**Sent:** 11 February 2013 11:03  
**To:** Planning  
**Subject:** Planning application S6/2013/0023/FP - Oak Cottage Residential Home, 4 Wilkins Green Lane

**District ref:** S6/2013/0023/FP  
**HCC ref:** WH/30/2013  
**HCC received:** 08/02/2013  
**Area manager:** James Dale  
**Case officer:** Lindsey Lucas

**Location**  
 Oak Cottage Residential Home, 4 Wilkins Green Lane  
 Hatfield

**Proposal**  
 Erection of two storey side and rear extension

TITLE
Proposed Ground Floor Plan

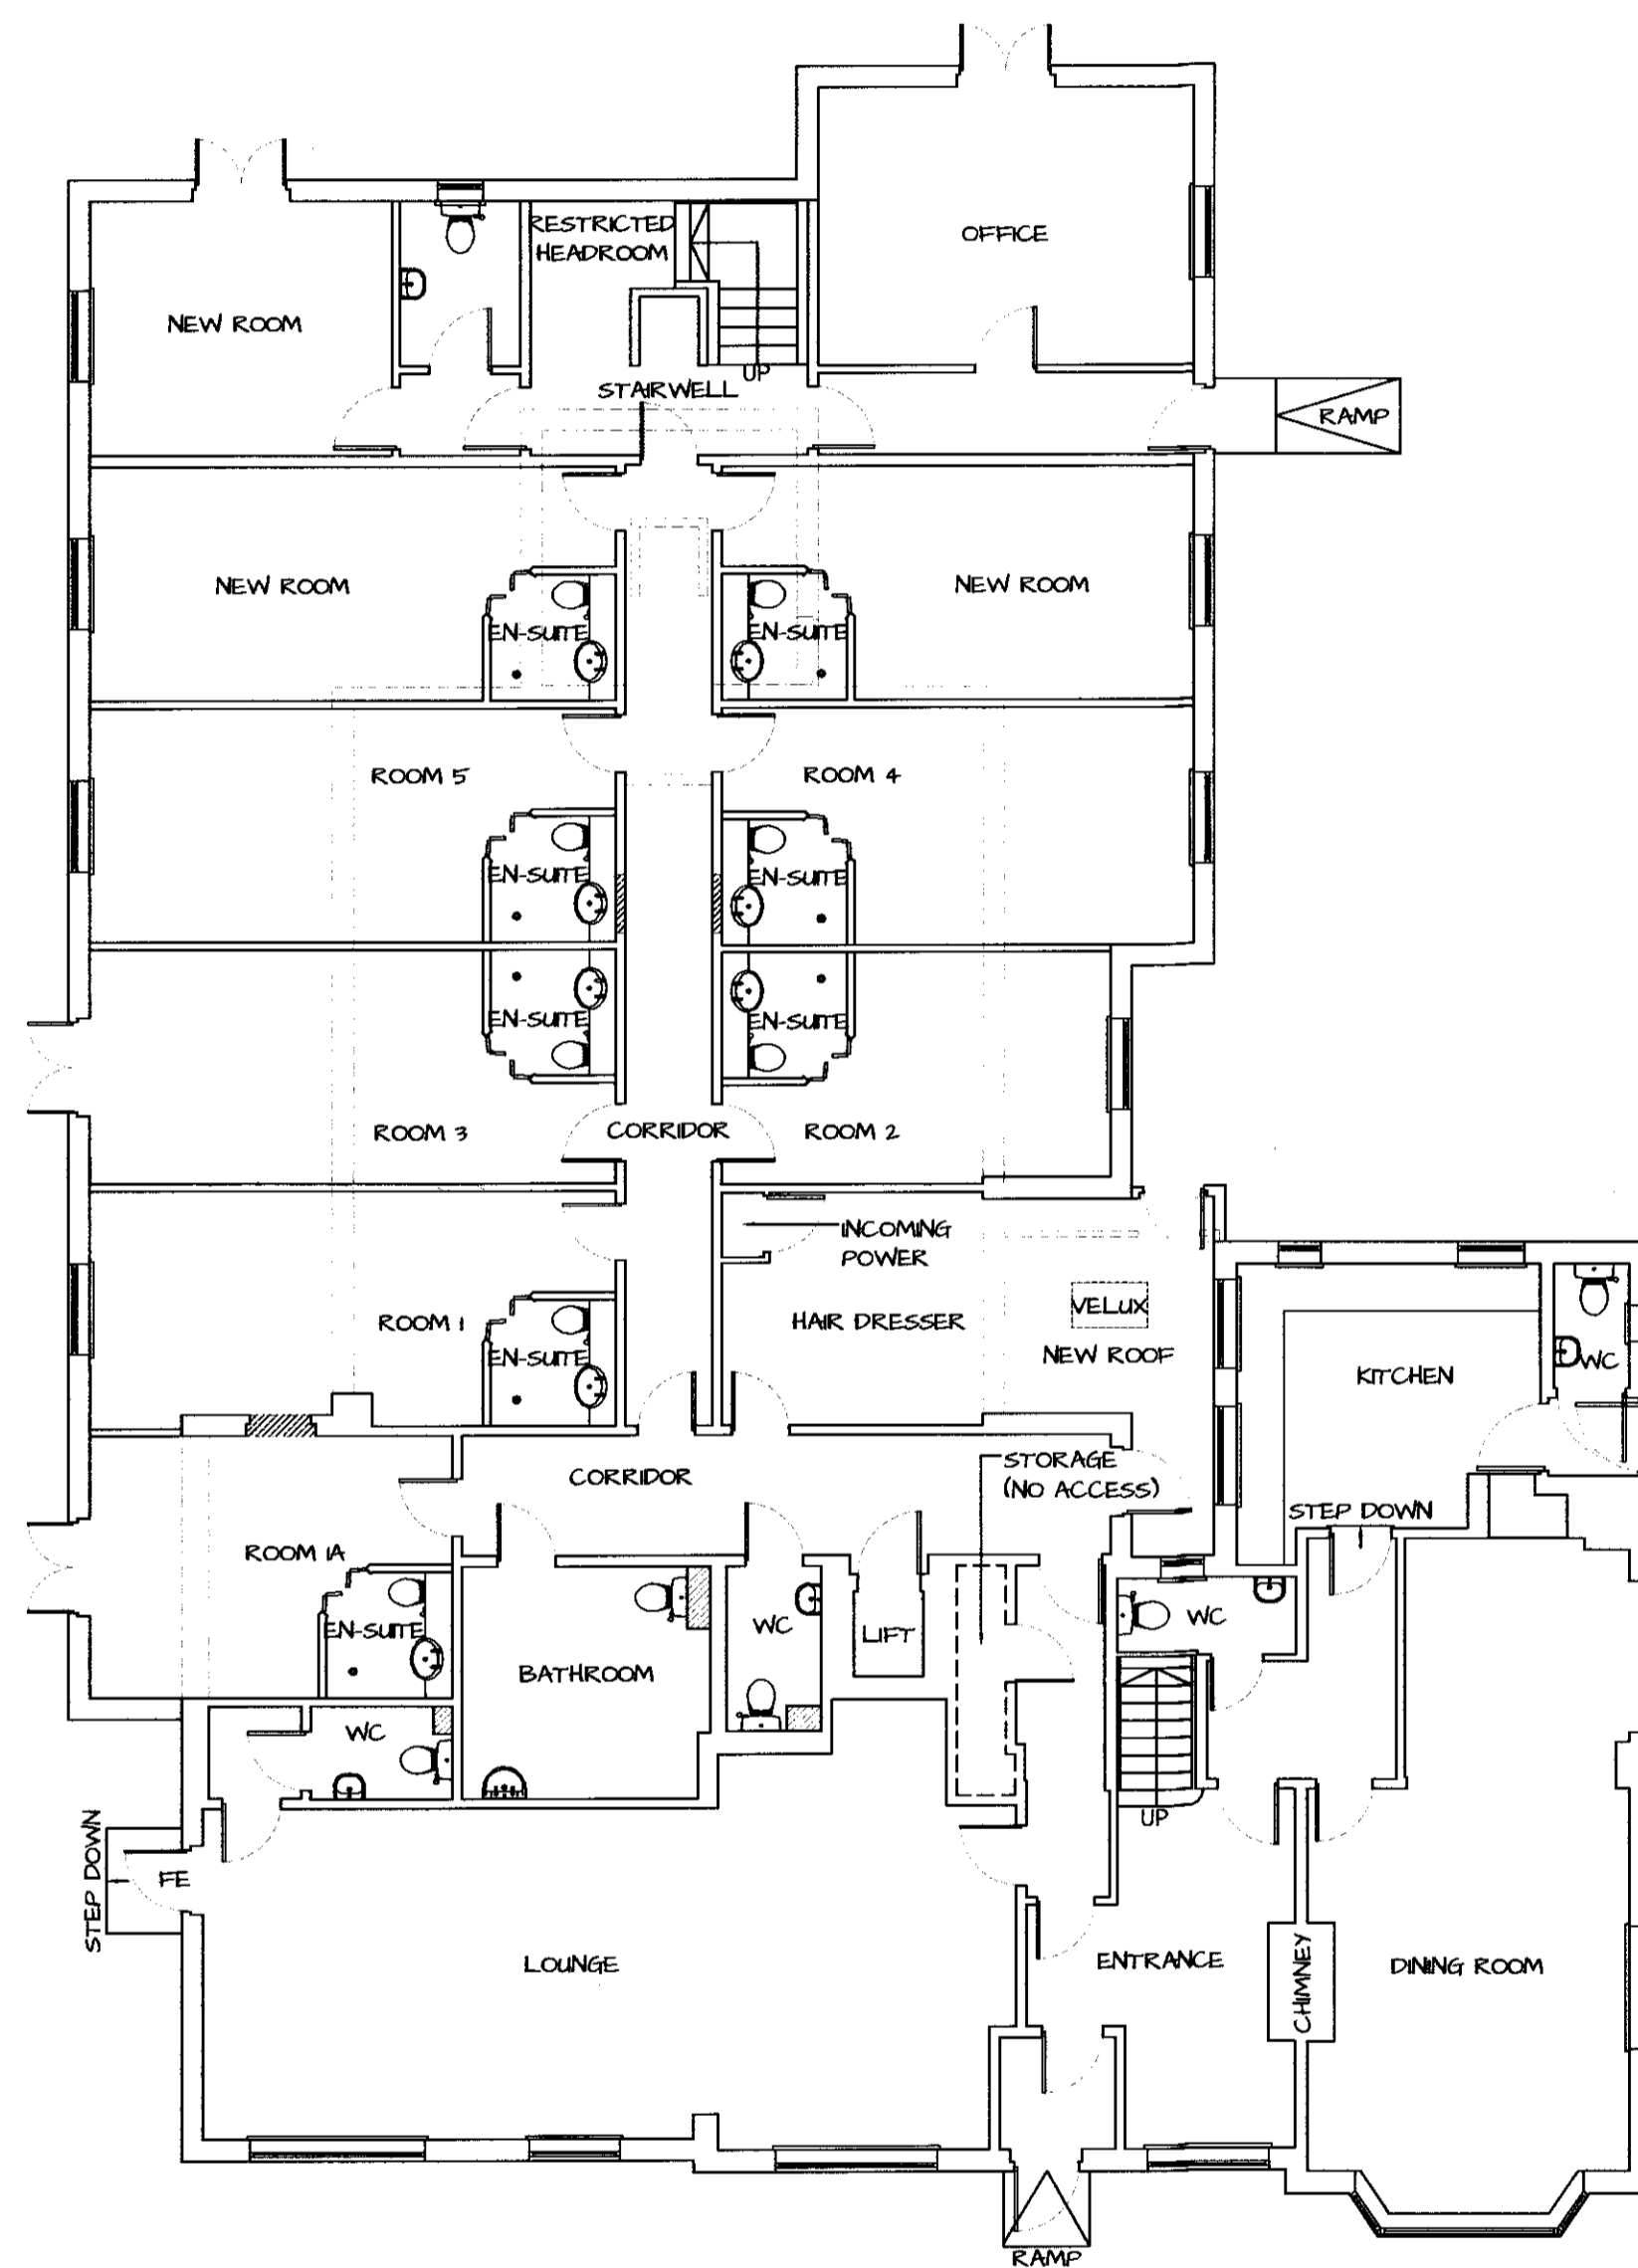
This application is for an extension to a care home on Wilkins Green Lane, which is an unclassified road designated as a local access road. It is proposed to use the existing vehicle access. The proposal will increase the number of rooms from 20 to 26. Although the Application Form indicates there are no proposed changes in car parking, the Design and Access statement indicates that on site parking will be increased from 10 to 16 spaces. No plan showing the proposed parking layout appears to have been included as part of the application and therefore I consider that any grant of permission should include the above condition to ensure that the parking layout allows vehicle to turn within the site and enter and leave in a forward gear.

1. C8.12 - The area set aside for car parking shall be laid out and surfaced, in accordance with a scheme which has been submitted to and agreed in writing by the local planning authority before the buildings hereby permitted are first occupied and shall be retained permanently there after for the accommodation of residents and staff and shall not be used for any other purpose.
